Our Ref: ID 1683  
Your Ref: SSD-11070211 – Mod 1

**State Significant Development Modification for New Public School in Mulgoa Rise,  
Glenmore Park**

Thank you for the opportunity to provide comment on the State Significant Development (SSD) modification for the New Public School in Mulgoa Rise, Glenmore Park. It is understood that the modification application seeks approval for the temporary placement of demountables to operate a temporary school for up to two years, whilst the permanent school is being constructed.

Figure 3: Proposed Development and 1% AEP Flood Extent.

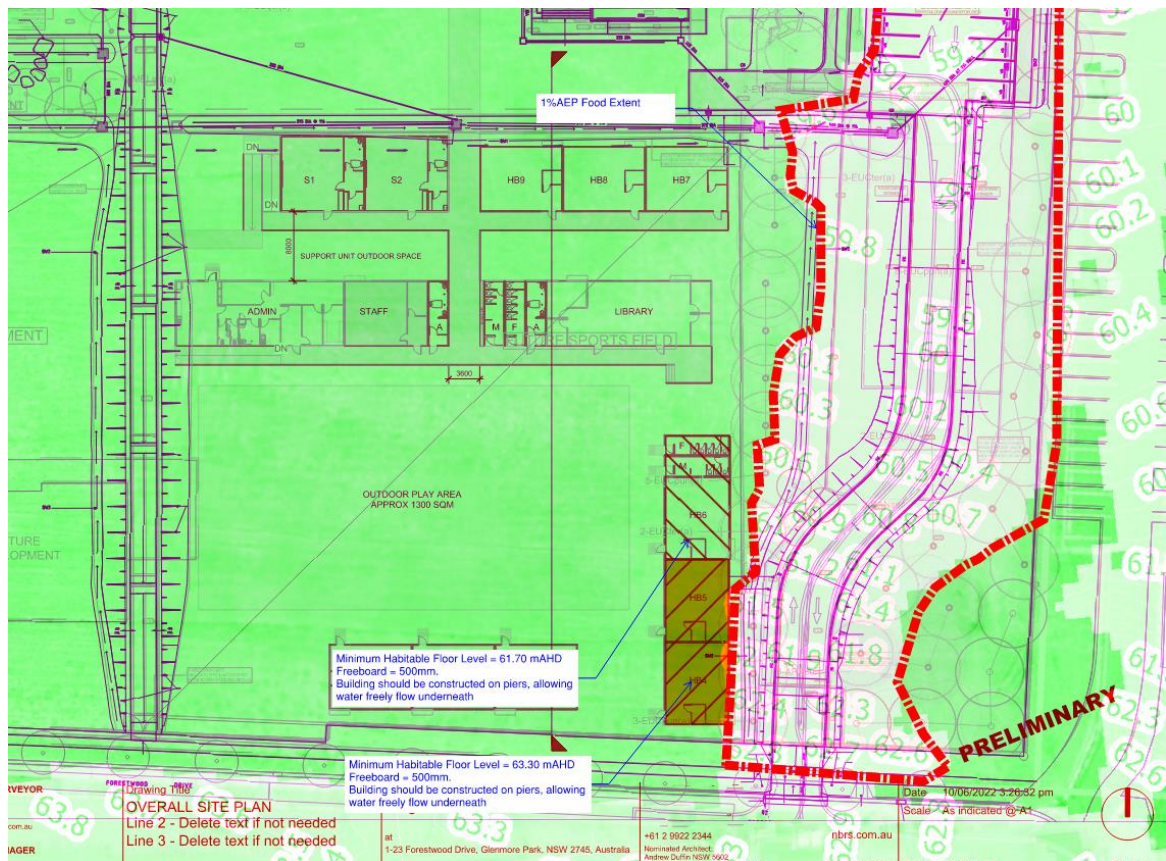
- The Flood Impact Assessment only considers the impacts of riverine flooding for a 1% AEP flood, not the PMF. **Risk assessment should consider the full range of flooding, including events up to the Probable Maximum Flood (PMF) and not focus only on the 1% AEP flood.** There is no information available for the site relating to Surveyors Creek, which may impact the site.
- **Risk assessment should have regard to flood warning and evacuation demand on existing and future access/egress routes. Consideration should also be given to the impacts of localised flooding on evacuation routes.** It appears that the proposed school becomes isolated by overland flooding by the time a 1% AEP flood is reached, and evacuation routes are no longer accessible. The study should consider floods that are also more frequent, e.g. 5% AEP, 10% AEP etc. to determine how frequently the

Figure 4: Proposed Development and PMF Flood Extent.

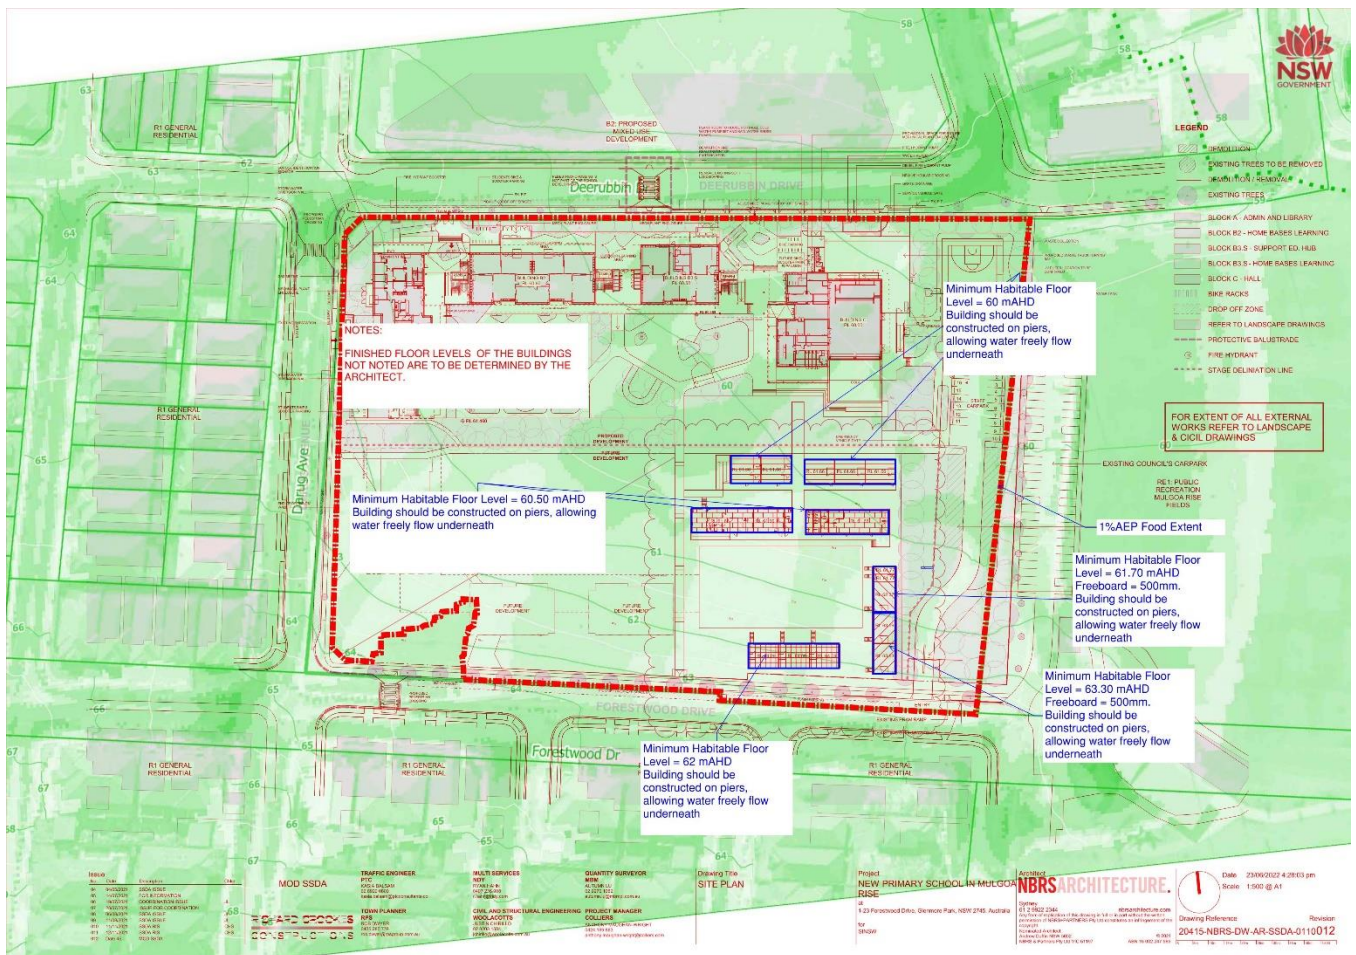
school is at risk of isolation. The school is then flooded in a PMF by shallow floodwater (<0.5m) across the entire site.
